## **Objections & Concerns**

The developers and their agents now acknowledge that there is a general presumption against new buildings in the Green Belt and this site, that of the former Castle Hill Hotel, lies in the Green Belt and within the curtilage of a Scheduled Ancient Monument and a designated local nature reserve.

Proposed Basement Floor Plan 1:100

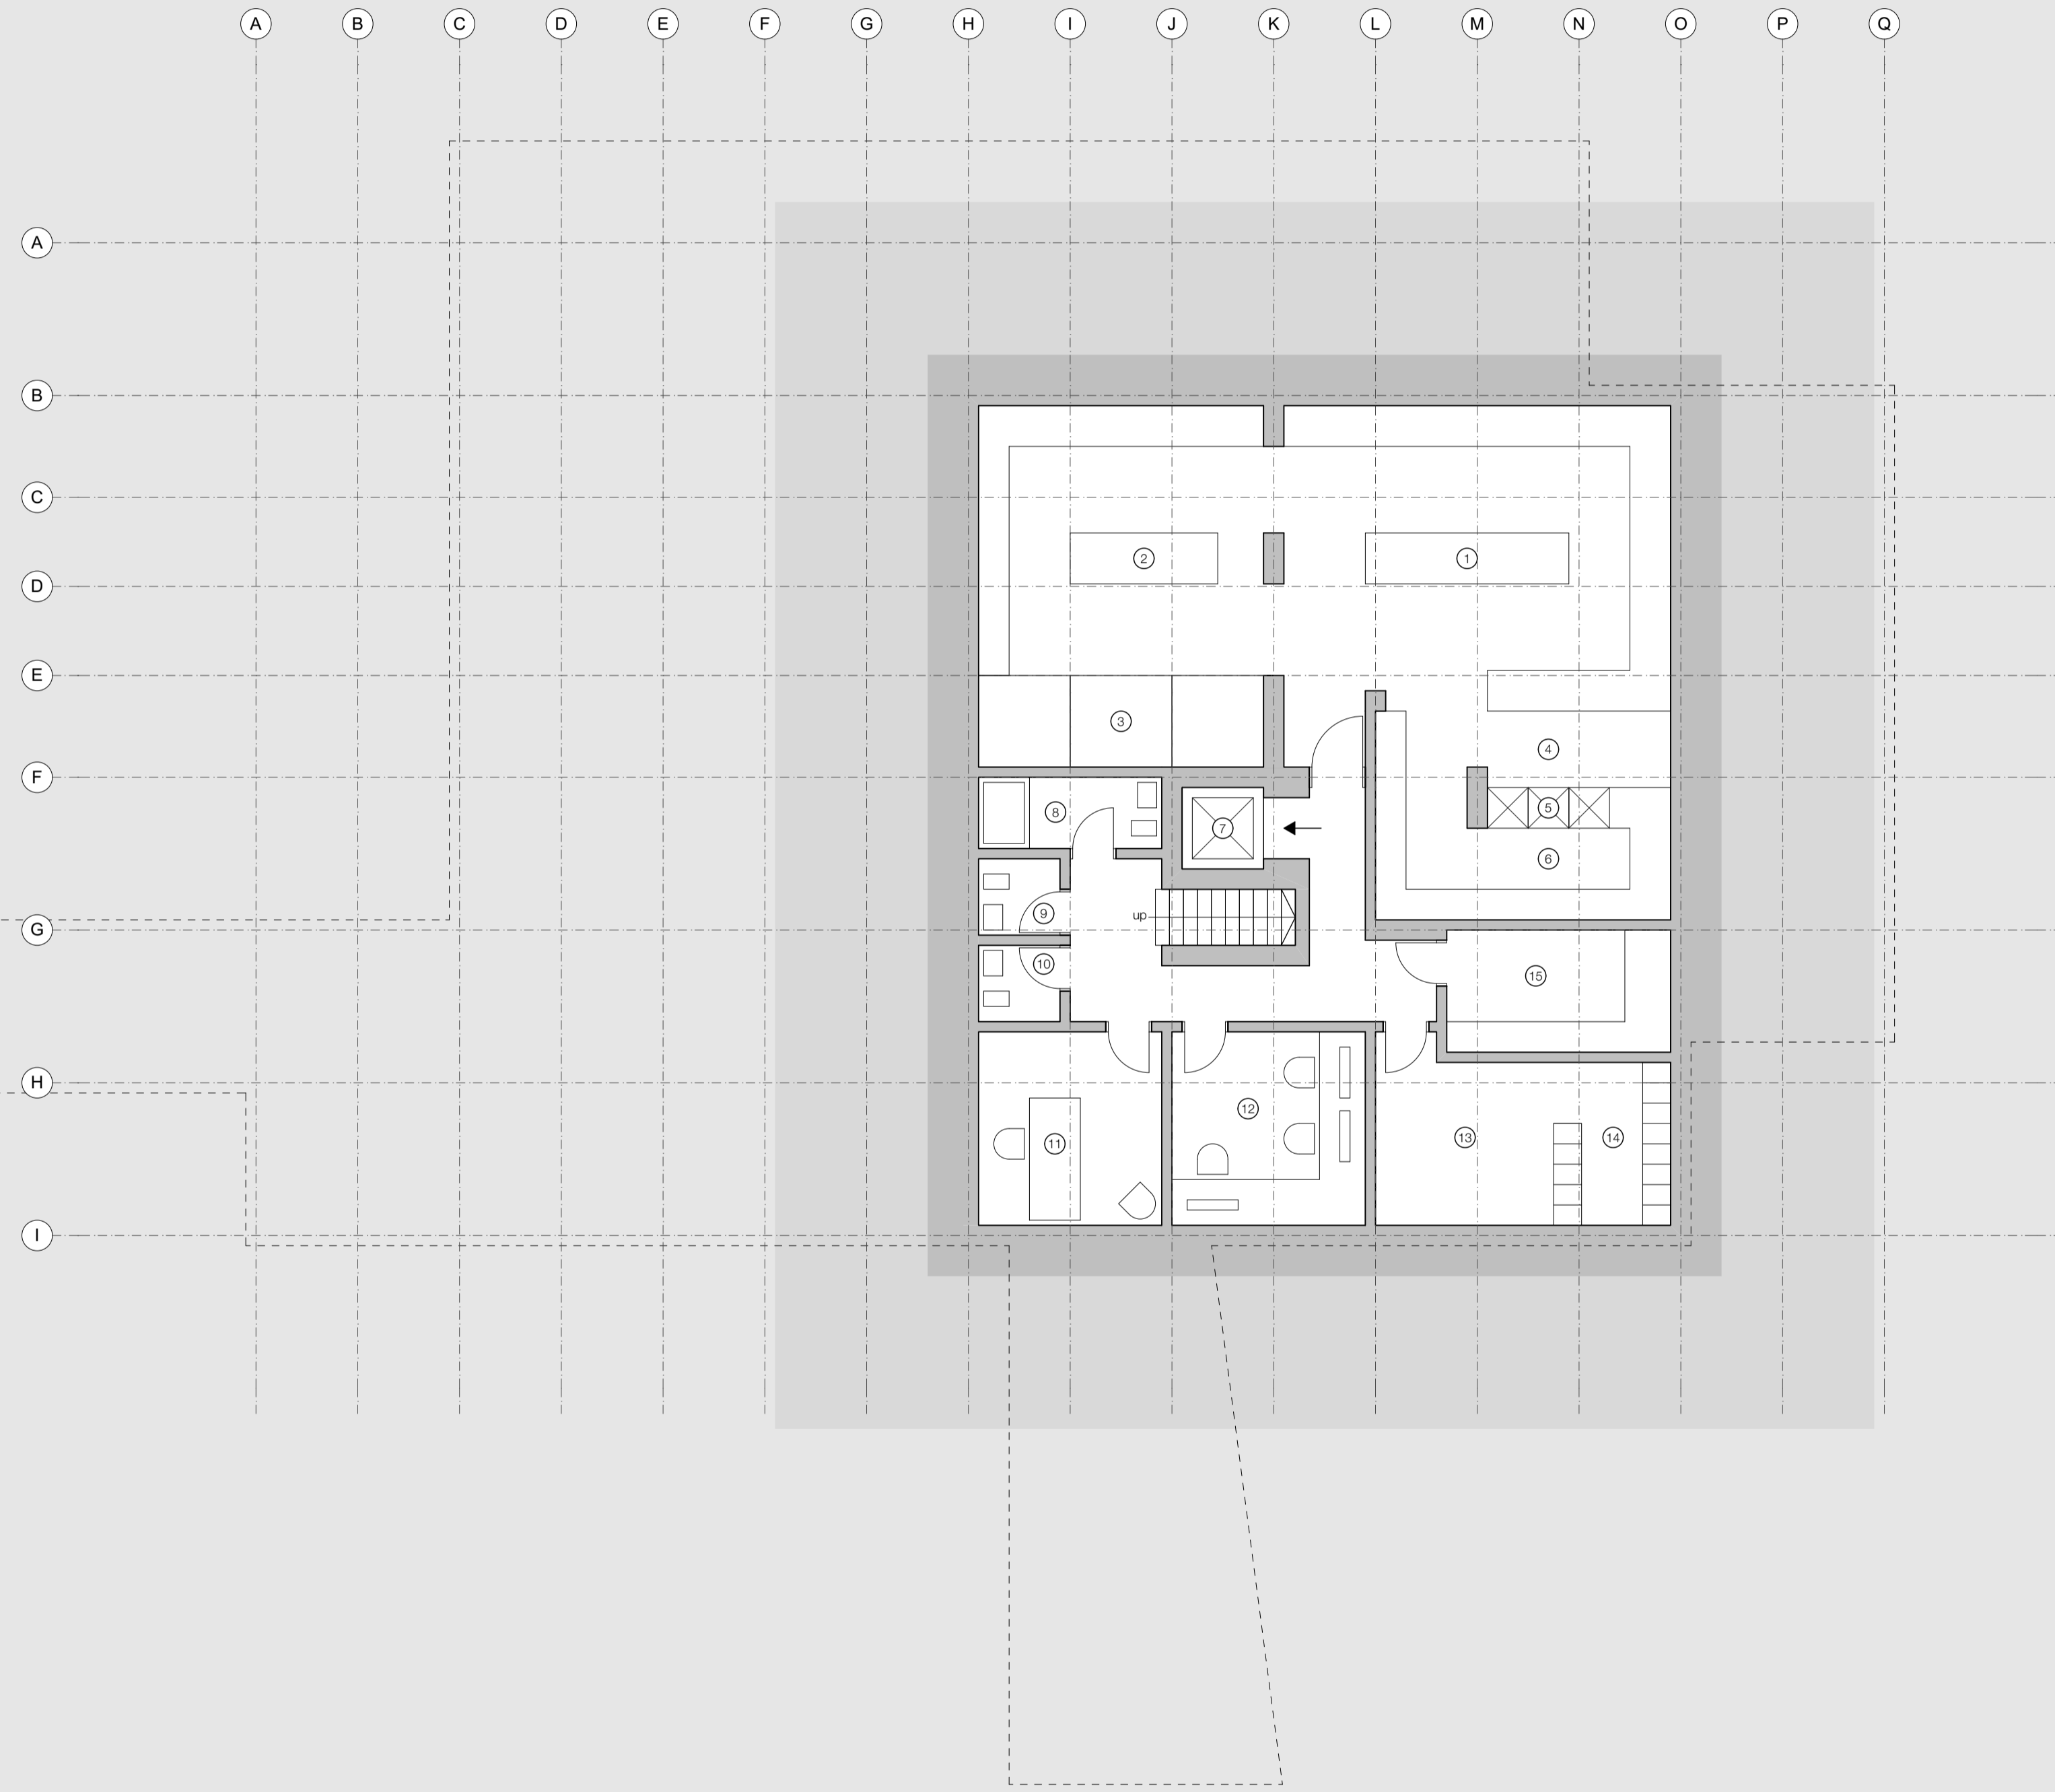
There is no apparent provision in the scheme illustrated for heating the building; no plant room and no 'chimneys'. No provision appears to have been made for ventilation of the large kitchen space which occupies a basement level, requiring deep excavation.

There appears to be only one entry/exit point to the basement kitchen. Is this safe? How will this impact on the delivery of goods and services and the removal of waste?

Already noted is the absence of ventilation to the kitchen area.
